Re: Permit #2212-162
Rader SFR Addition and Remodel
7310 86th Ave SE
Intake Comment Response Letter

Regarding the combined intake comments dated 1/4/23 for the remodel/addition permit application listed above, we would like to provide the following corrections and locations on the drawings where they can be found (responses are bulleted and italicized below summarized comment):

SITE PLAN

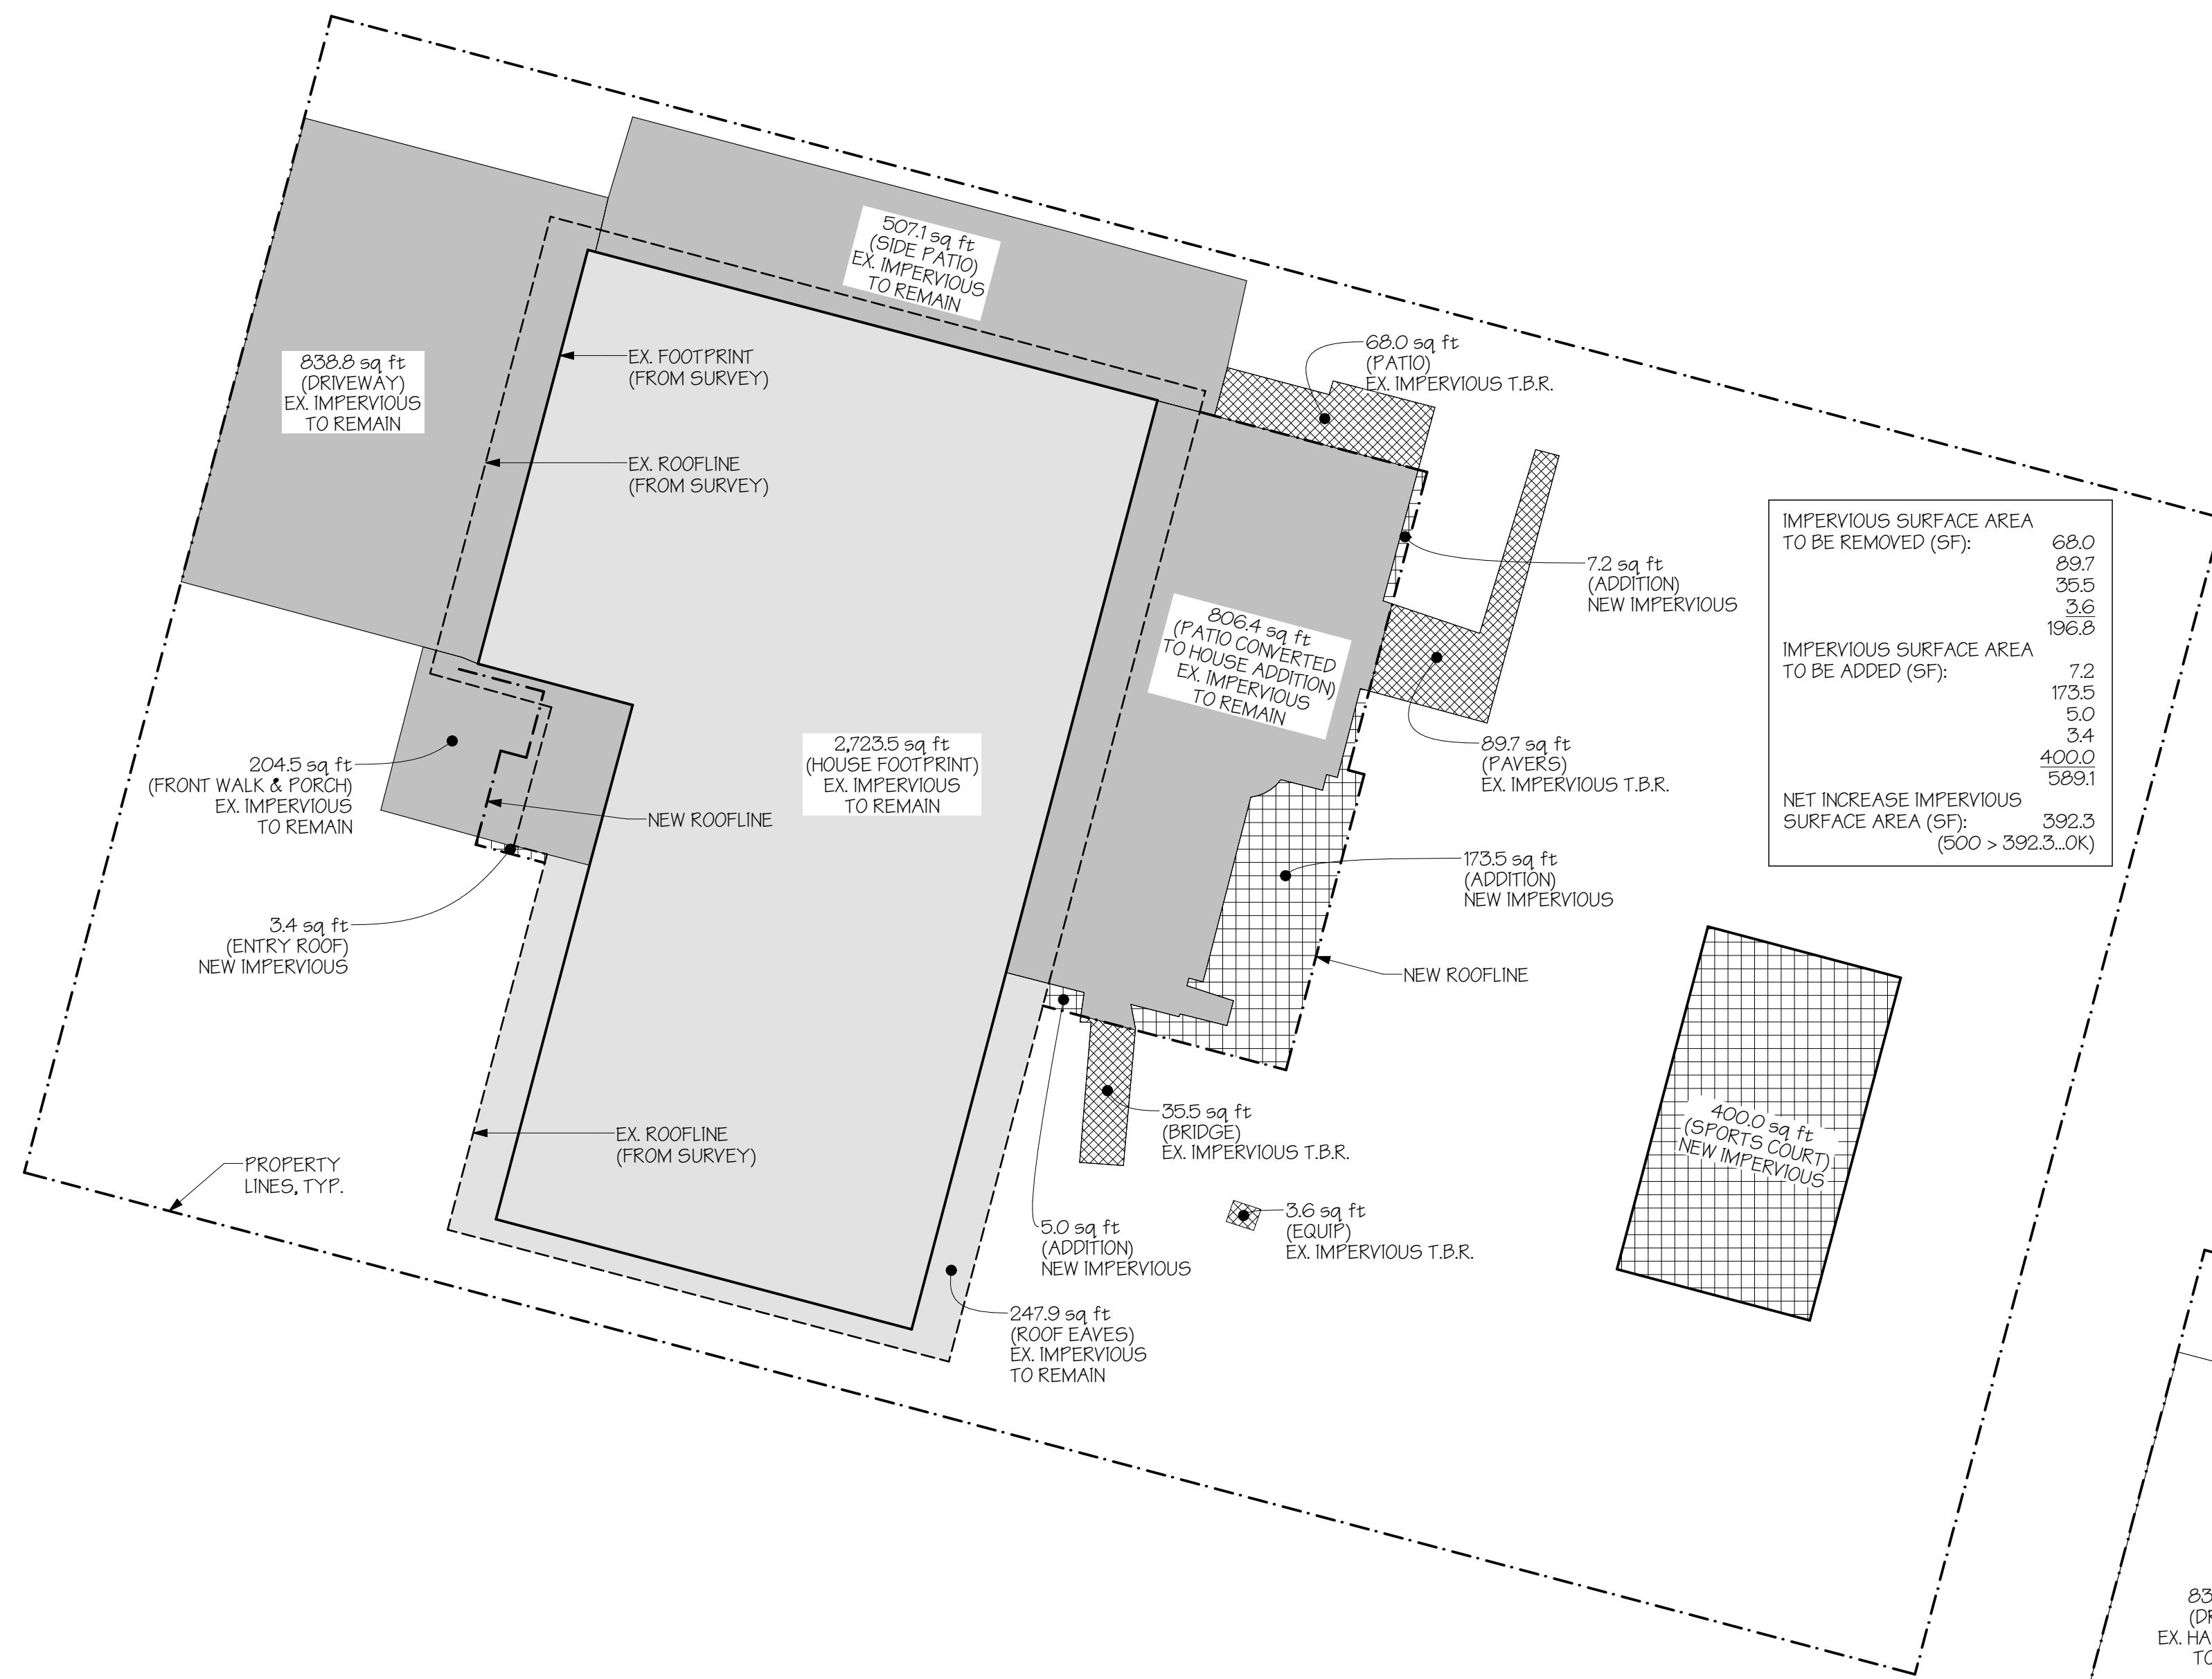
1. Show geological hazardous areas on site plan per GIS map.
 - *See sheet 02. Note has been added to site plan.*
2. Separate Critical Area Review 2 permit is needed. Development application for CAR2 permit needs to be completed as part of building permit intake application completion.
